This is to certify that Perham Carole A/Robert Ferr
has permission to Rebuild garage on existing foundation at single family residence
AT 38 Summit St City of Portland 377 E002001

City of Portland, Maine - Building or Use Permit Application

Proposed Use: single family residence with garage rebuilt on existing foundation	Proposed Project Description: Rebuild garage on existing foundation at single family residence
--	--

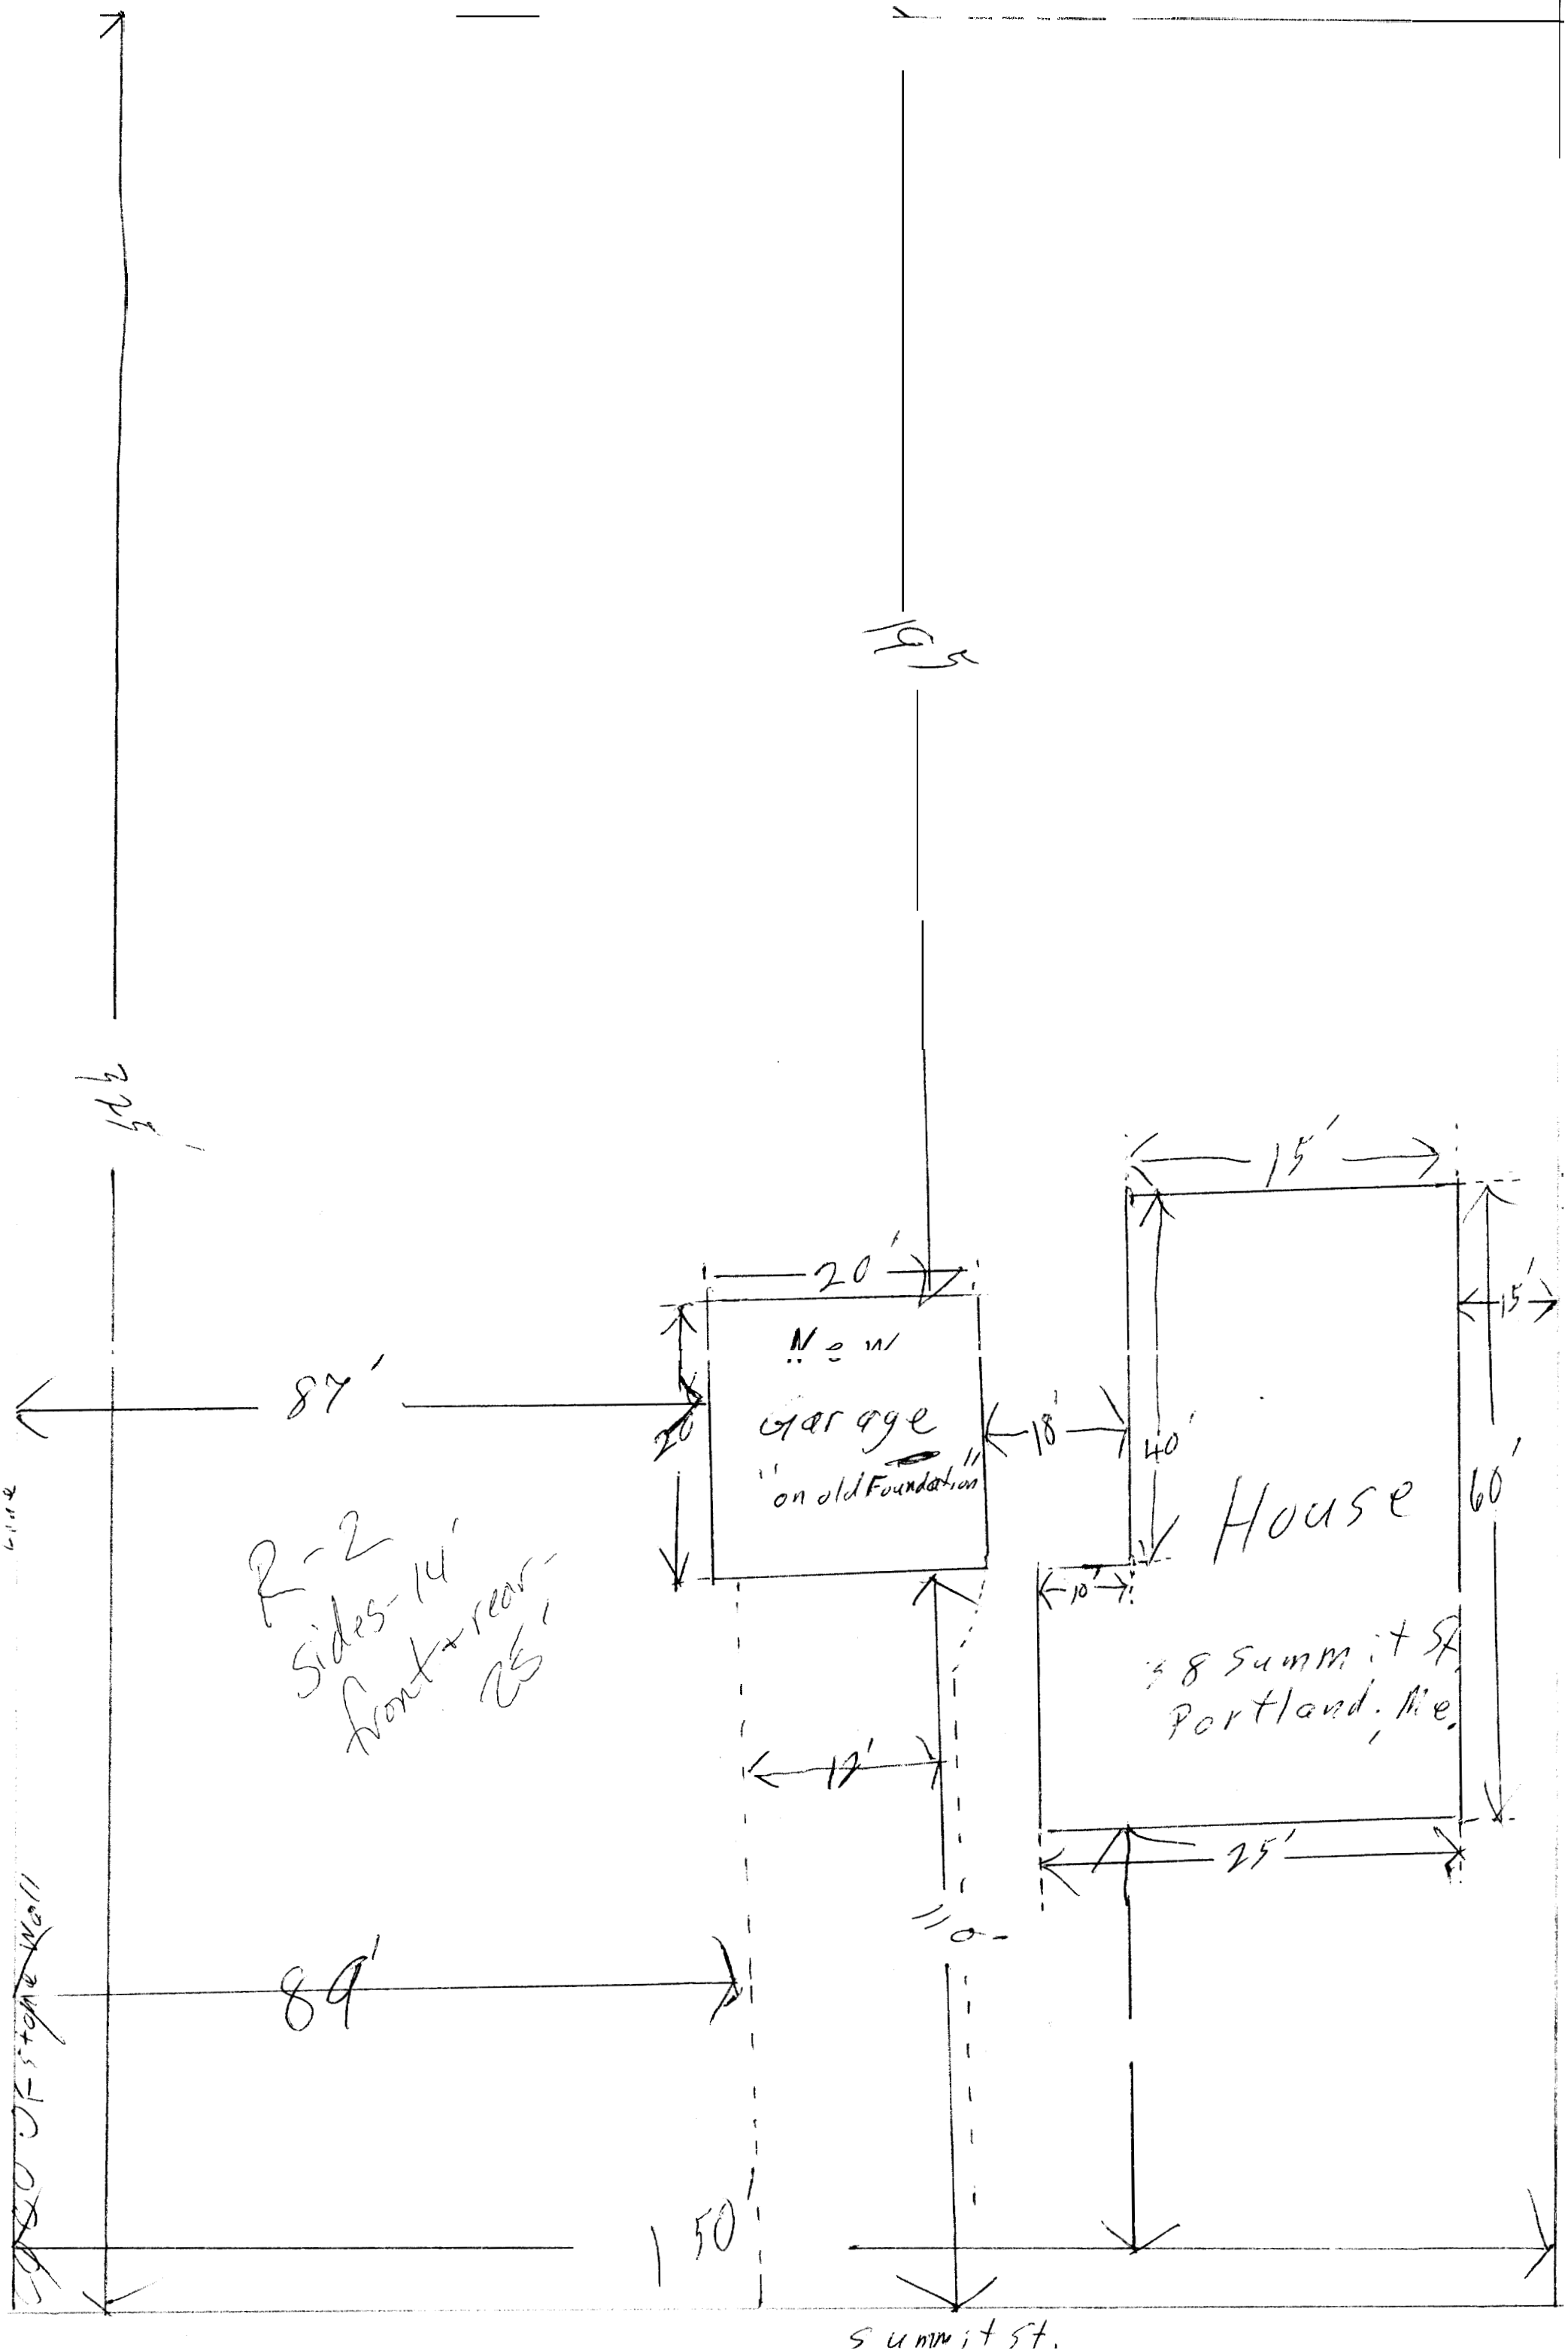
8124105-tmm: need 2" x 8" rafters, need 2- 2" x 8" s header over garage doors, need fully labeled cross section - went over w/builder.
